Our ref: MidCoast Regional Organics Facility (SSD-84090218)

Subject: Request for Additional Information

Attachment 1

Figure 1: Leachate and bunding plan

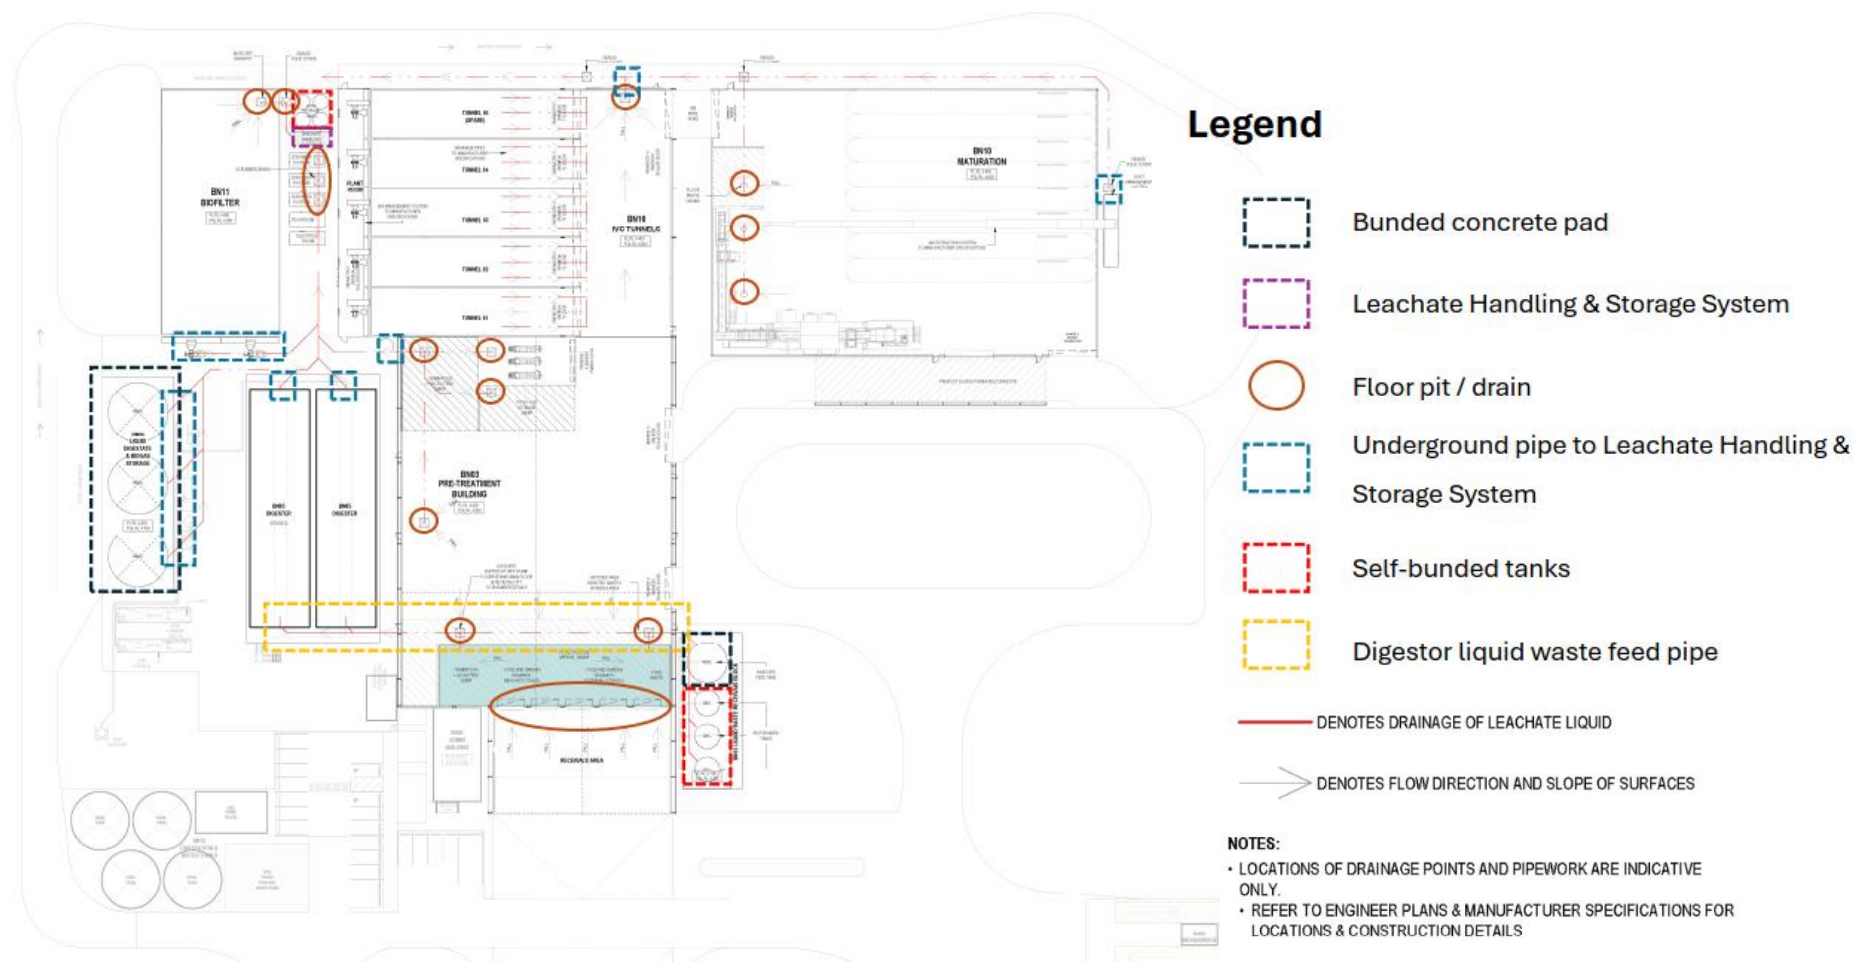
- Identify on the site plan where the final product will be stored (if not within the bunkers shown in Figure 20 of the EIS).
- Describe the proposed backup power system.
- Outline how FOGO will be transported to the anaerobic digestion facility.
- Describe the proposed bunding, including its location.
- Confirm the anticipated construction timeframe and whether construction will be staged.
- Provide plans/drawings for the proposed signage and fencing.

Figure 2: External noise sources

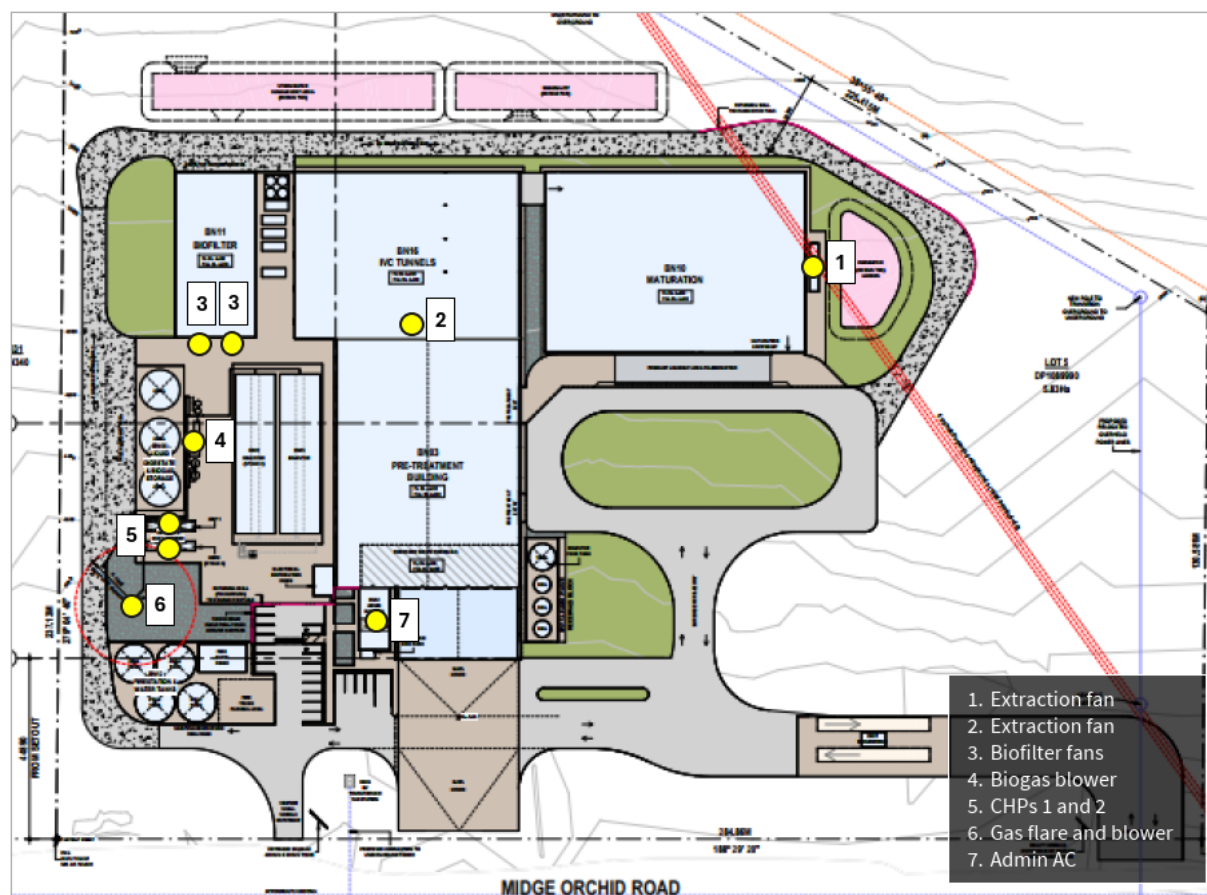
- The Traffic Impact Assessment and Noise Impact Assessment contain contradictory information. Please clarify the number of heavy vehicles per day and per hour, and update the relevant assessment(s) accordingly.
- Provide a swept path analysis for a heavy vehicle unloading liquid waste.
- Provide a swept path analysis for a heavy vehicle loading product while another vehicle is simultaneously unloading liquid waste.
- Describe how onsite traffic will be managed to avoid conflicts.
- The EIS states that delivery of inputs and collection of products will occur 24 hours a day, 7 days per week; however, the TIA indicates that truck movements would be limited to daytime hours. Please clarify and update the documentation accordingly.
